Kirklees Planning Department

14/07/23

**I object to the proposal 2021/92003 for 61 apartments at Prickleden Mill on the following grounds:**

PROPOSED SITE SECTIONS WITH PREVIOUSLY APPROVED OVERLAID SHEET 1 OF 2

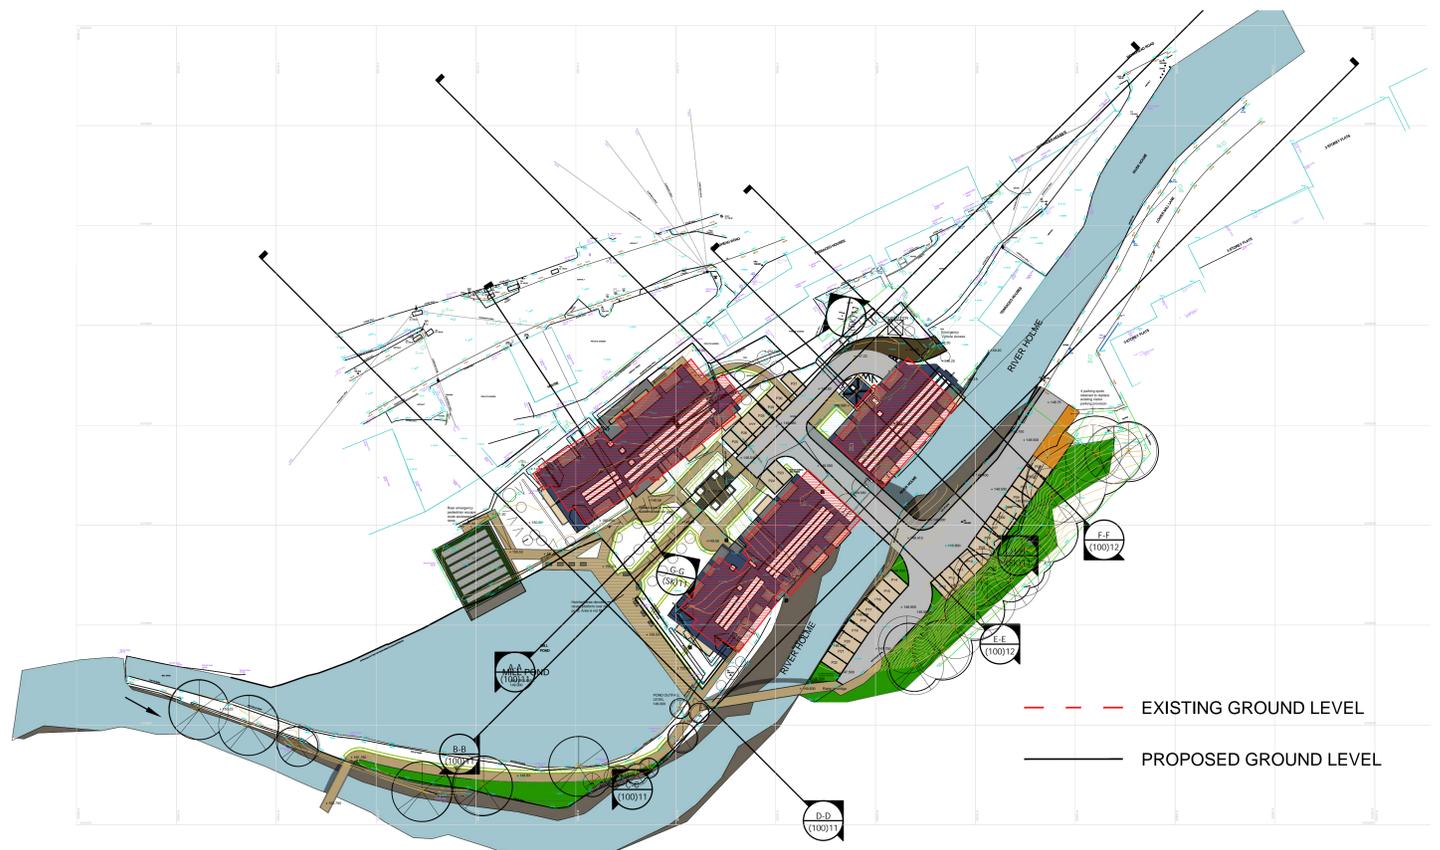
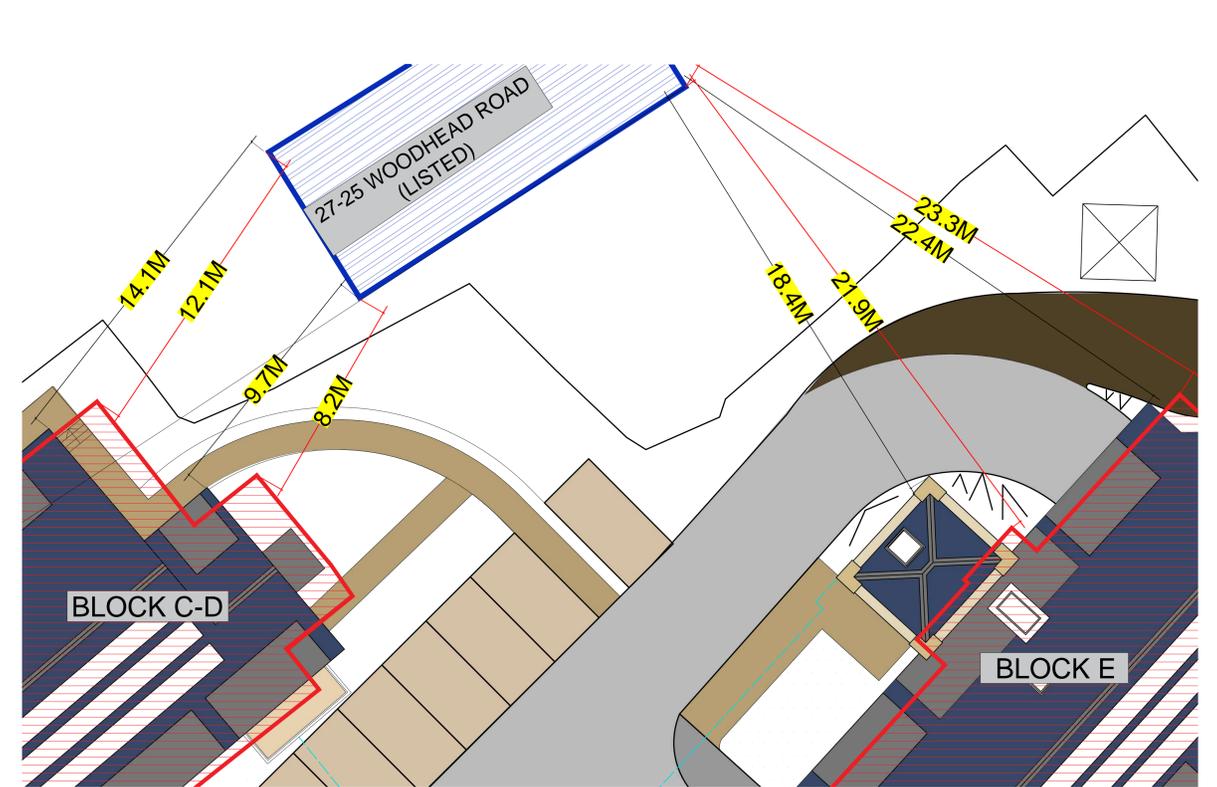
The eaves height of the current proposal is in places 3 storeys higher than the consented scheme revised in 2018 and considerably higher than the 2 storey mill buildings that previously occupied the site.

**Tree Protection Plan to BS5837:2012 at:
 Prickleden Mills, Holmfirth**

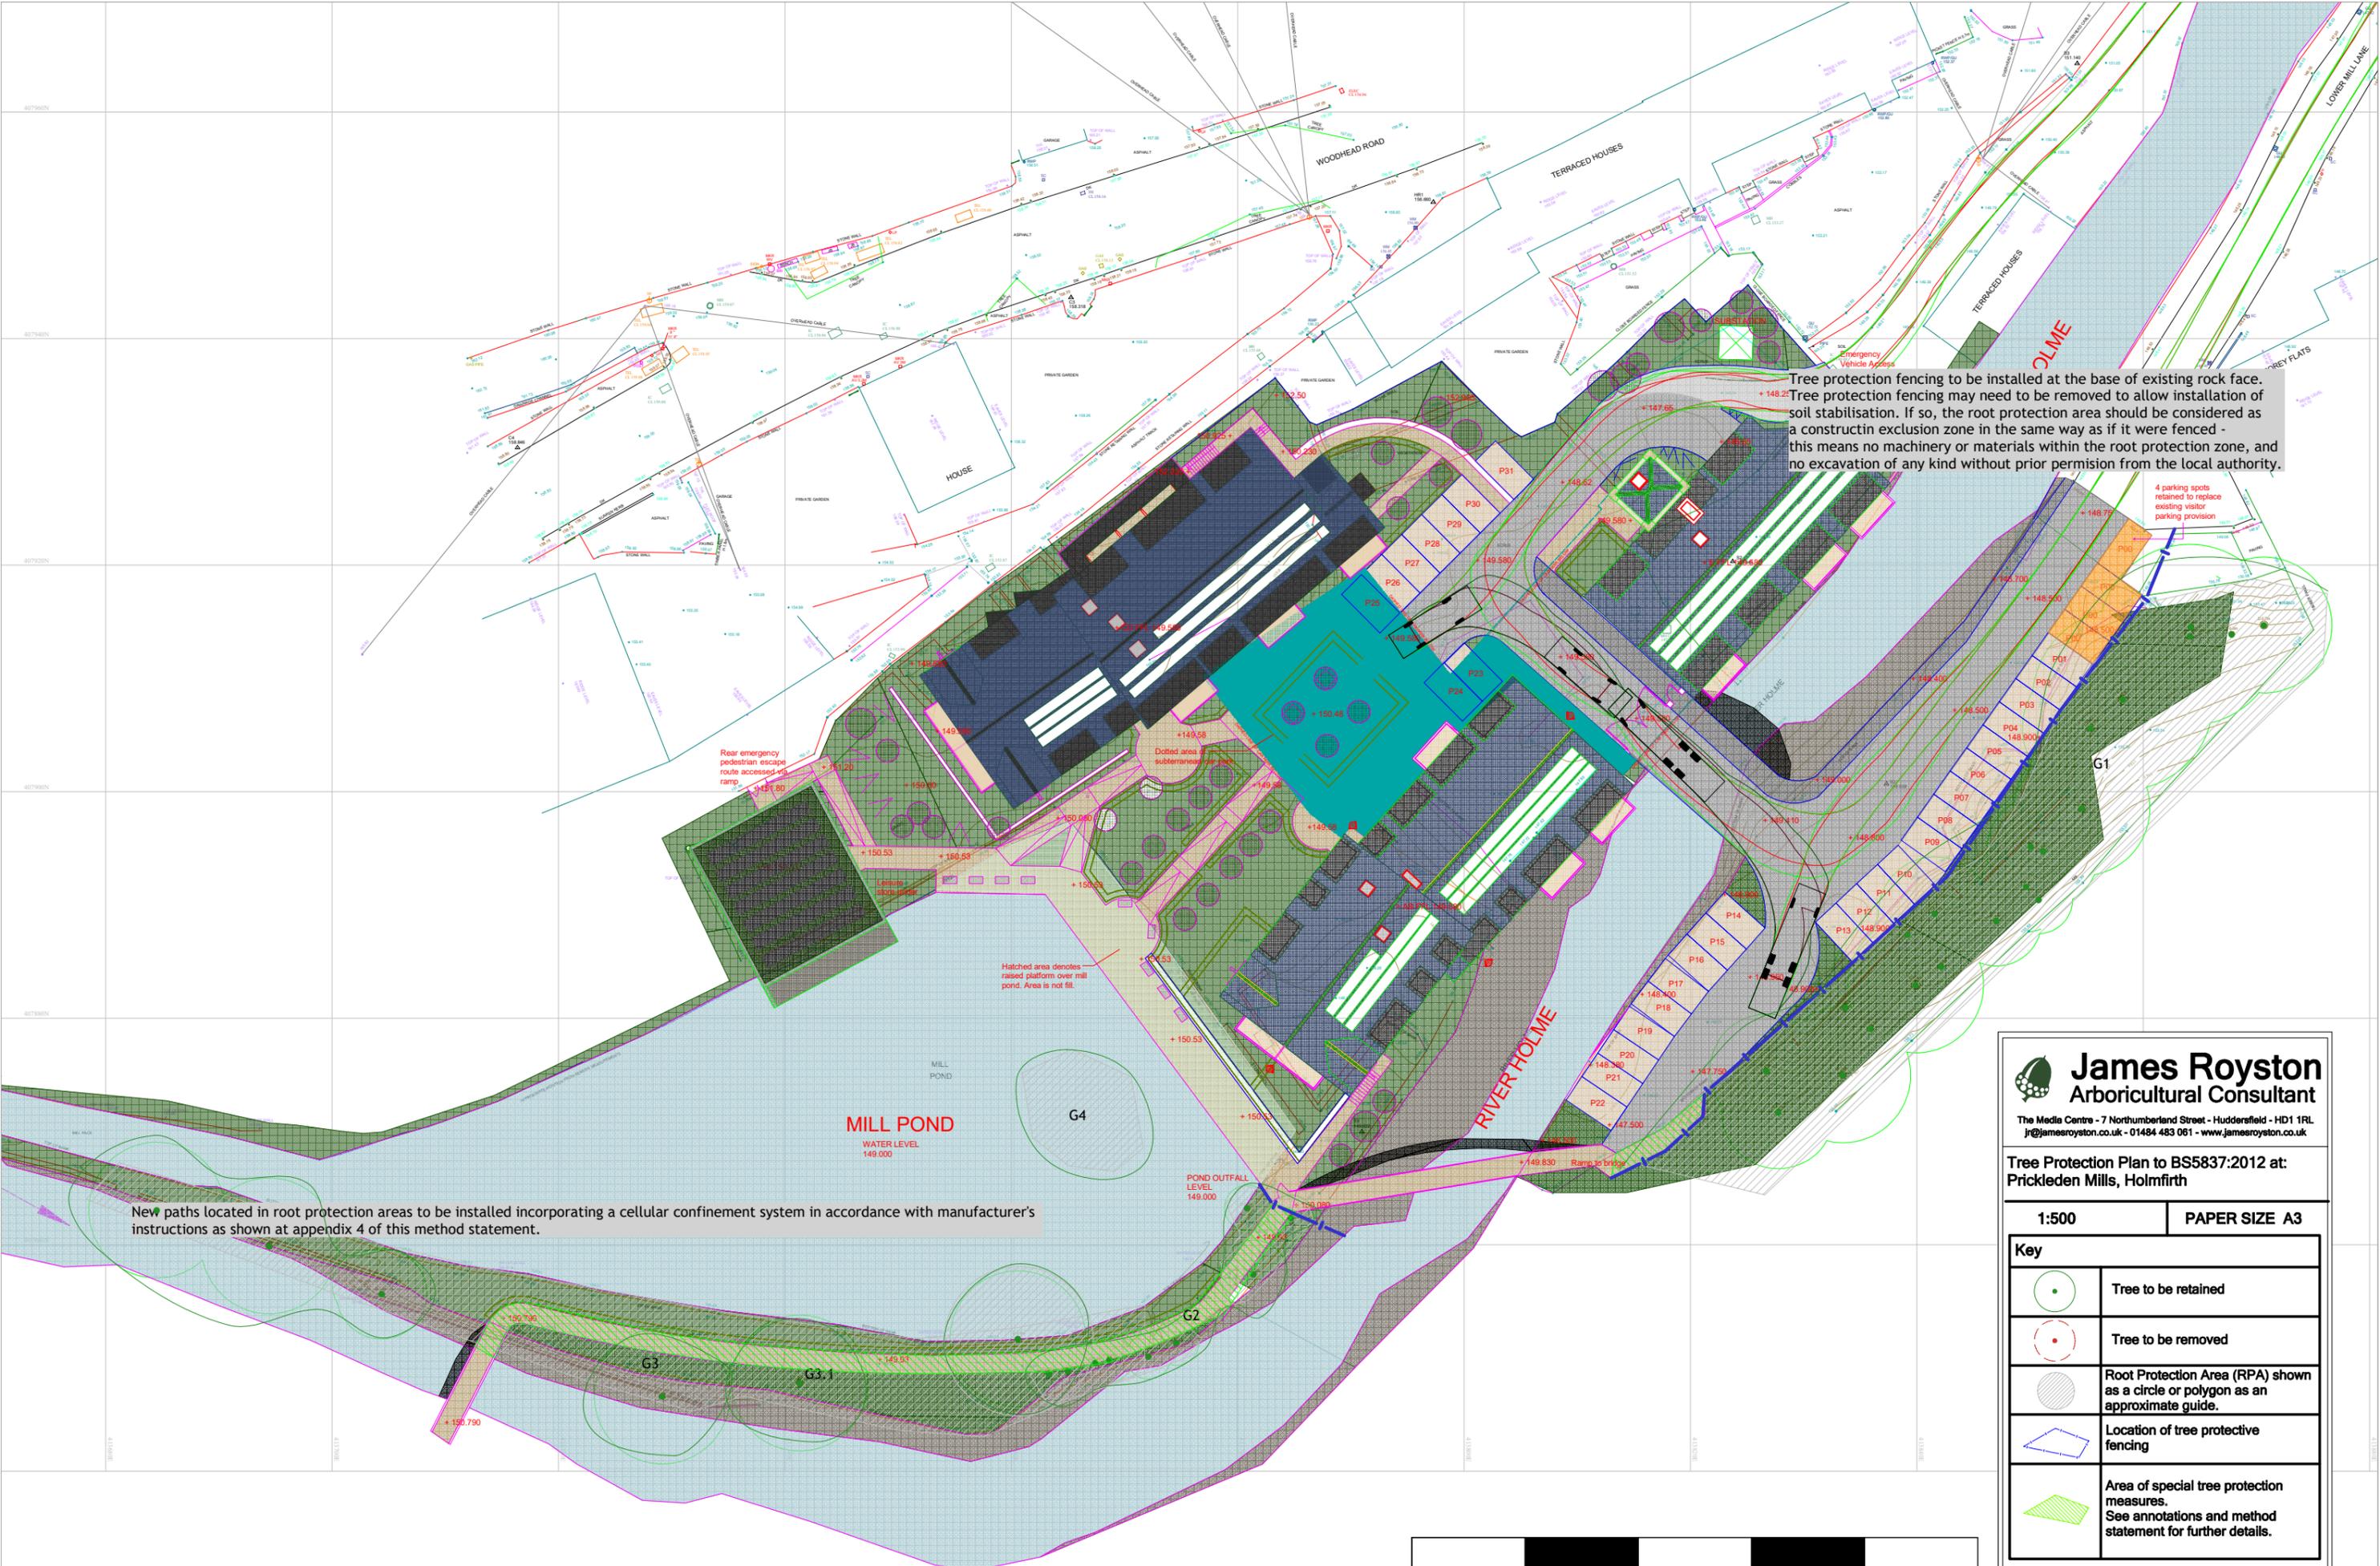
'Around the pond is a raised walkway, which cantilevers over the pond'. This is not illustrated on any artist's impressions but would impact the appearance and biodiversity of the mill pond.
